## KITTTITAS COUNTY COMMUNITY DEVELOPMENT SERVICES

### **RE: Bach Boundary Line Adjustment (BL-21-00023) – Deemed Incomplete**

Parcel # 635436

Parcel# 135436

RECORD OF SURVEY
MIKE BACH
 NW 1/4, SE 1/4 SEC 35, T. 20 N., R. 17 E., W.M.
 ELK SPRINGS RD.
 PARCEL NO. 635436
 ELLENSBURG WA

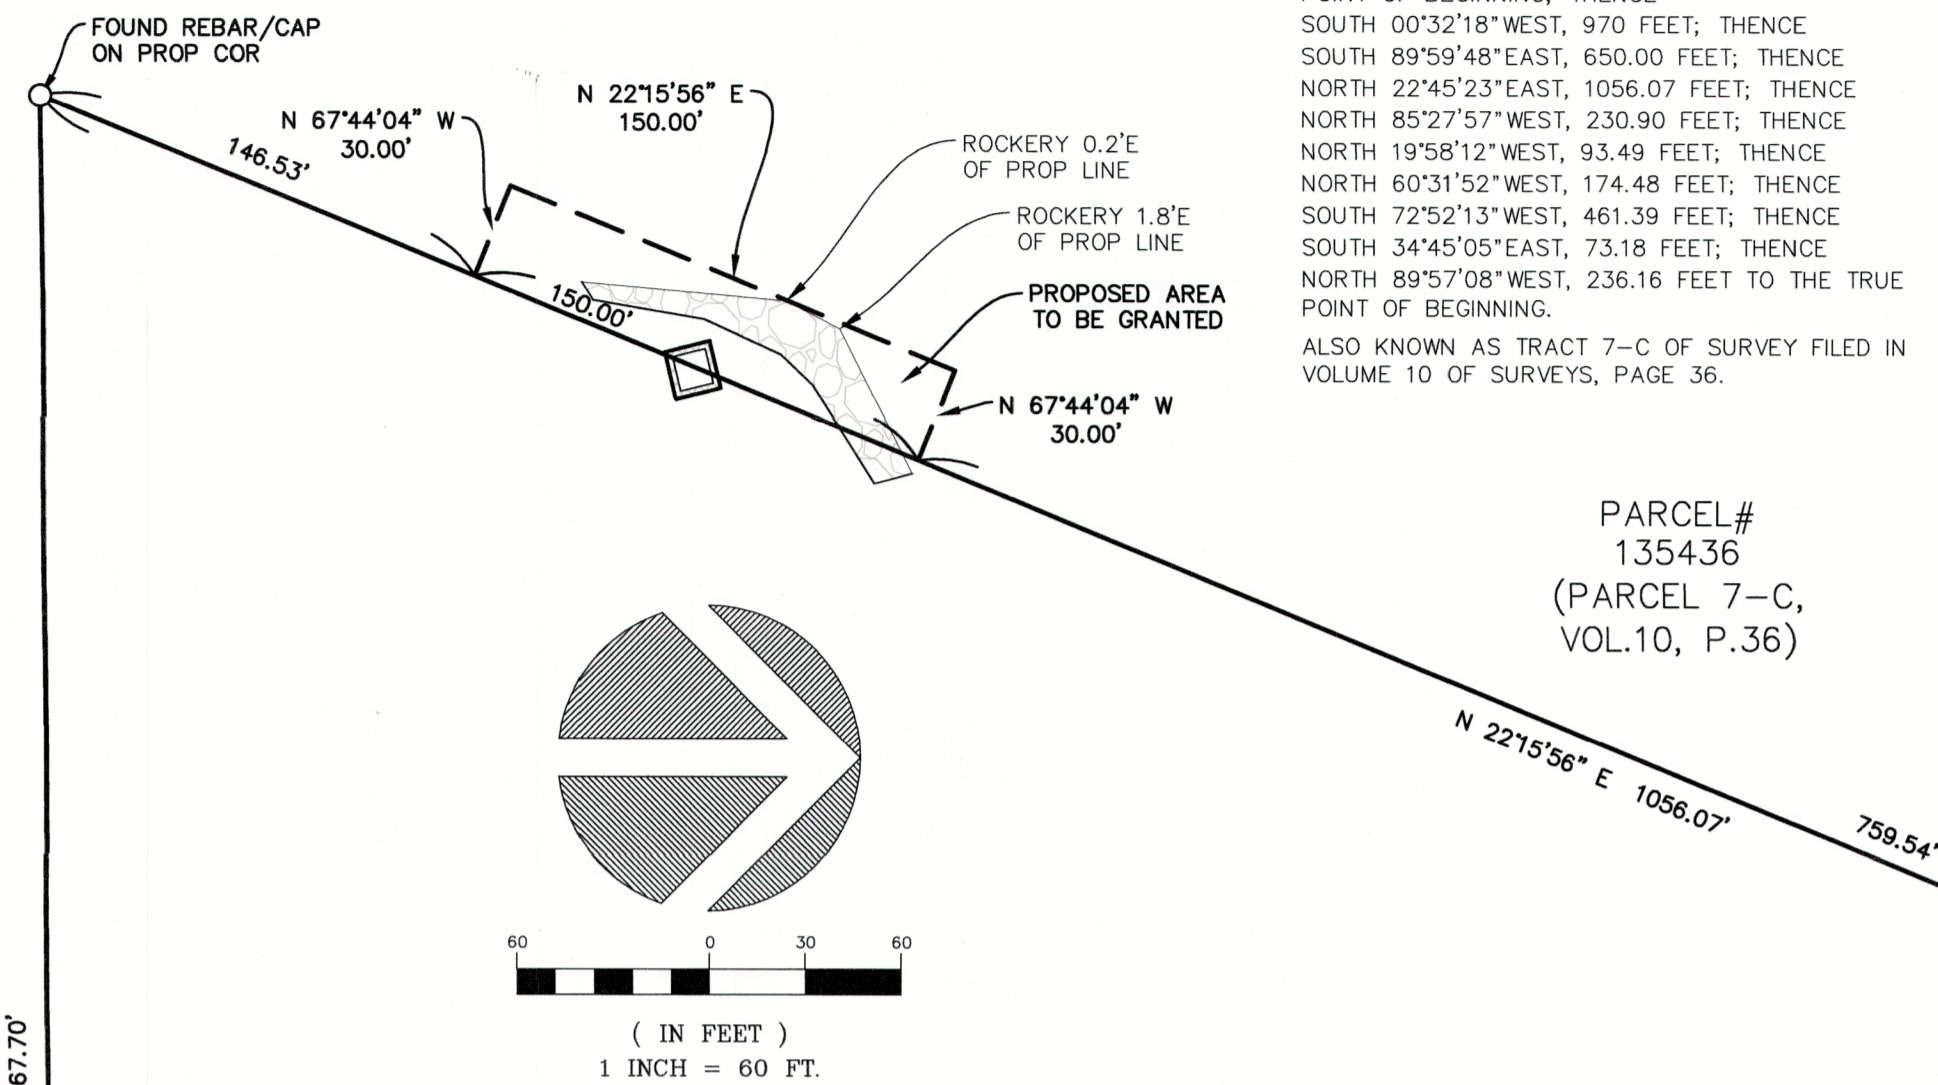
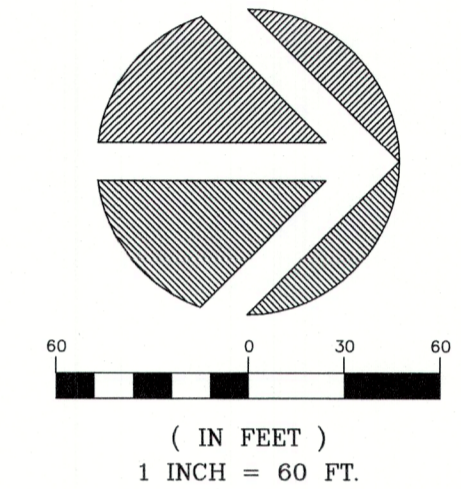
- A unified site plan drawn to scale of existing lot lines and proposed lot lines with:
  - distances of all existing structures,
  - access points, and
  - well heads and septic drainfields.

The site plan you submitted does not include the above elements.
